SSD_7417: REGIMENT MIXED-USE REDEVELOPMENT, UNIVERSITY OF SYDNEY, DARLINGTON CAMPUS

ADDENDUM

UNIVERSITY OF SYDNEY RESPONSE TO ADDITIONAL SUBMISSIONS

JULY 2017

Figure 4.1: Service Vehicle Access

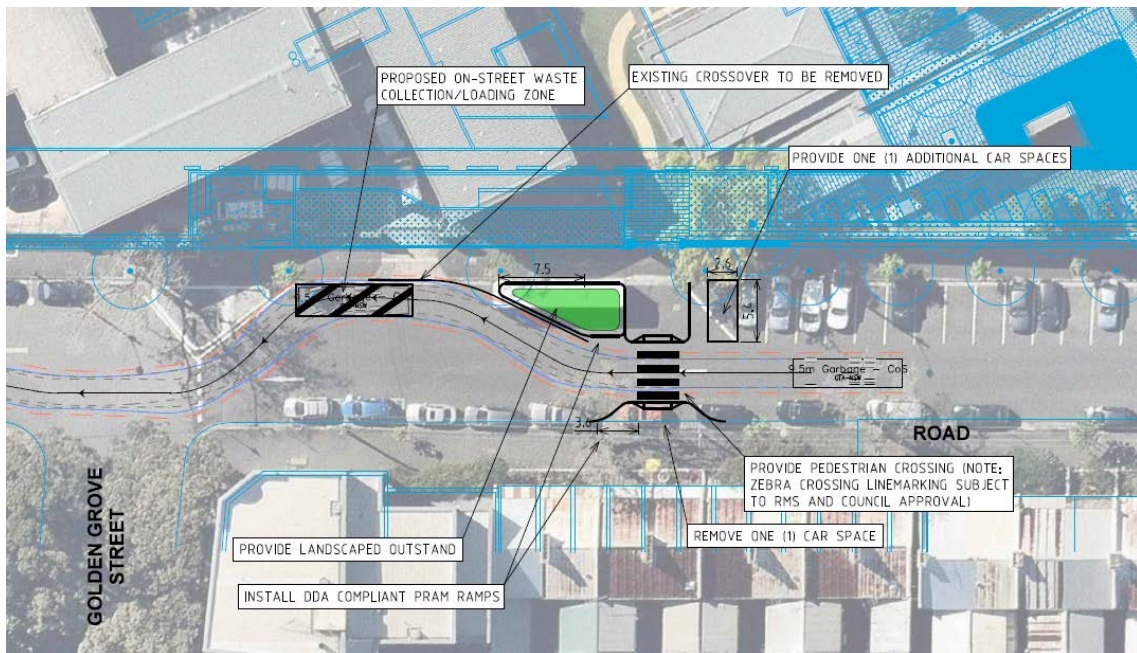
CoS ISSUE	USYD PROJECT RESPONSE
9. Lack of details on-site servicing and loading facilities. Changes to on-street parking conditions requires approval from Council's <i>Local Pedestrian, Cycling and Traffic Calming Committee</i>	A loading zone is to be provided on Darlington Road on the northern aspect of Darlington Road to the east of a line of Golden Grove Road. This area has been designed in consultation with GTA to accommodate the swept path requirements of a City of Sydney 9.25m garbage truck as shown below in Figure 4.1. The proposed location of this loading zone utilises the existing site's driveway so there are no net impacts to on street car parking. The loading zone location is also appropriately juxtaposed against the Regiment building's outdoor hard stand bin storage area (contained within the site) and designed for easy bin collection.  Figure 4.1
